Our Case Number: ACP-324410-26

Re: Proposed West Clare Railway Greenway Section 1: Kilrush to Kilkee Project
Kilrush to Kilkee via Moyasta, Co. Clare

Our Ref: P800107/2026

Proposed Development: West Clare Railway Greenway - Section 1 Kilrush to Kilkee
--

**ROUGHAN & O'DONOVAN**  
CONSULTING ENGINEERS

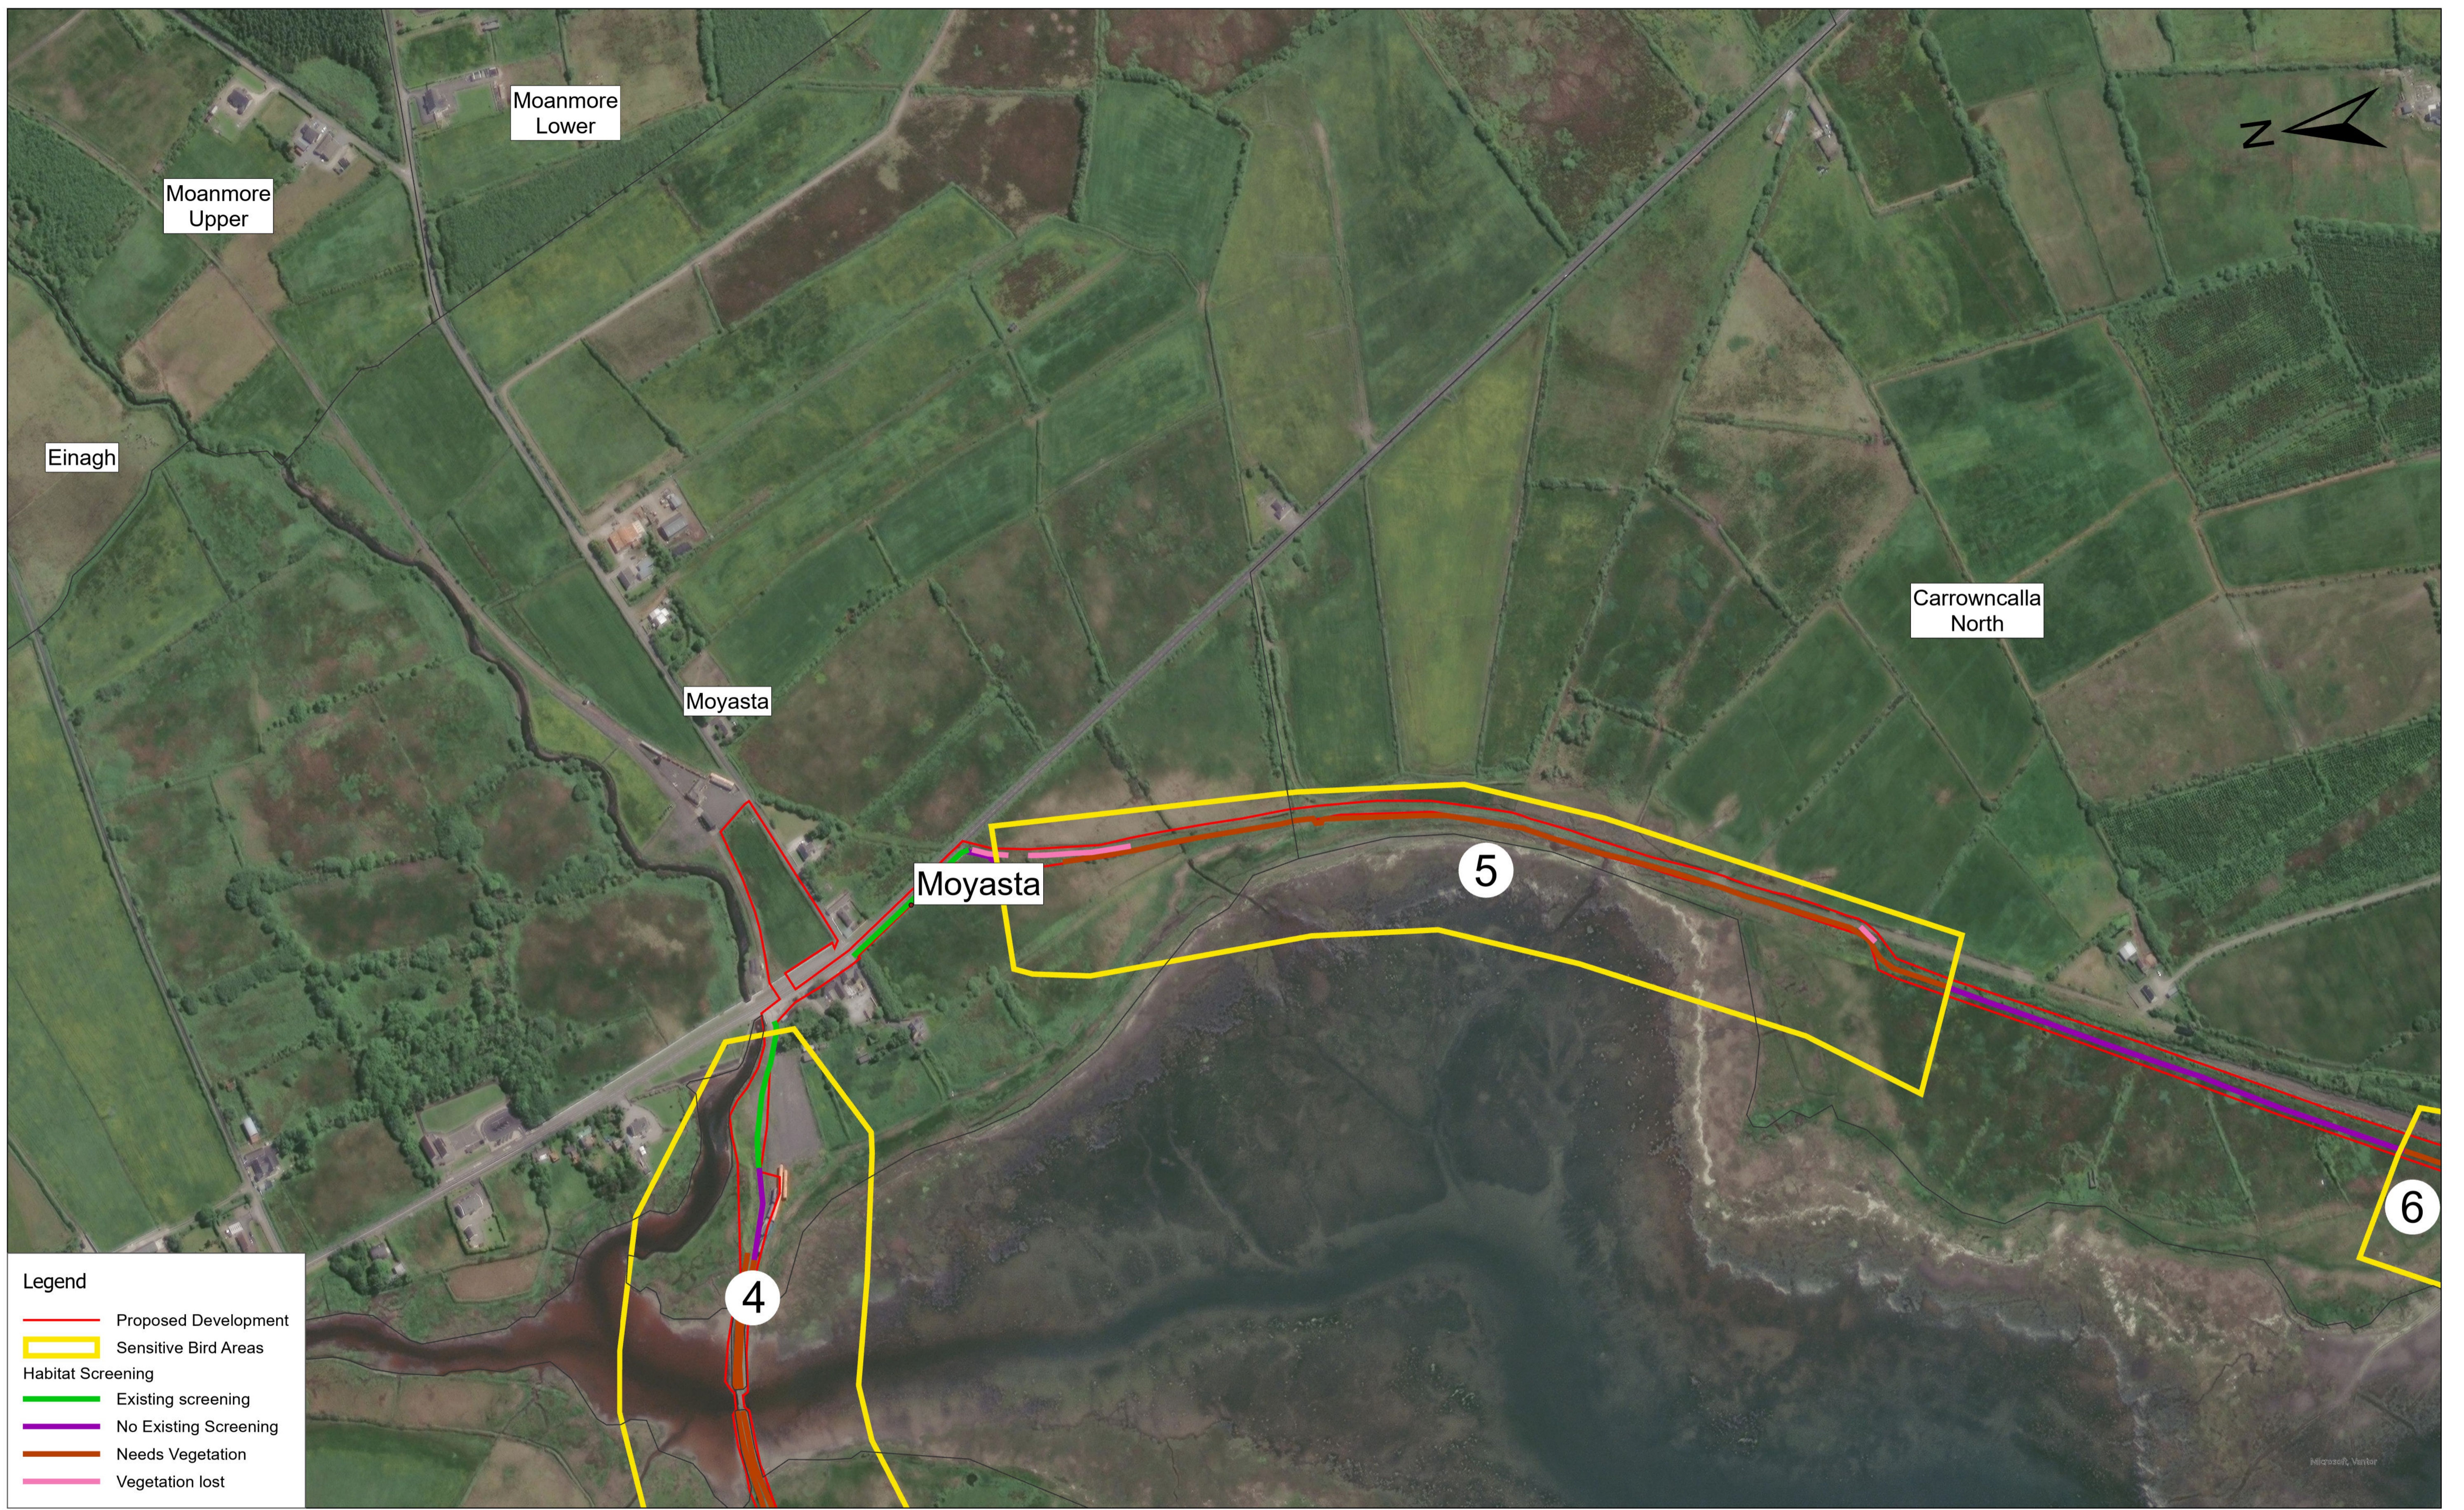
The proposal relies substantially on visual screening to reduce disturbance.

The Department welcomes the proposed screening and monitoring measures but notes that the NIS itself acknowledges that direct evidence demonstrating the effectiveness of screening in this context is limited.

Further information should therefore demonstrate how screening will work in practice and how its effectiveness will be monitored.

The design of screening and planting should avoid creating artificial predator perches overlooking important bird habitat.
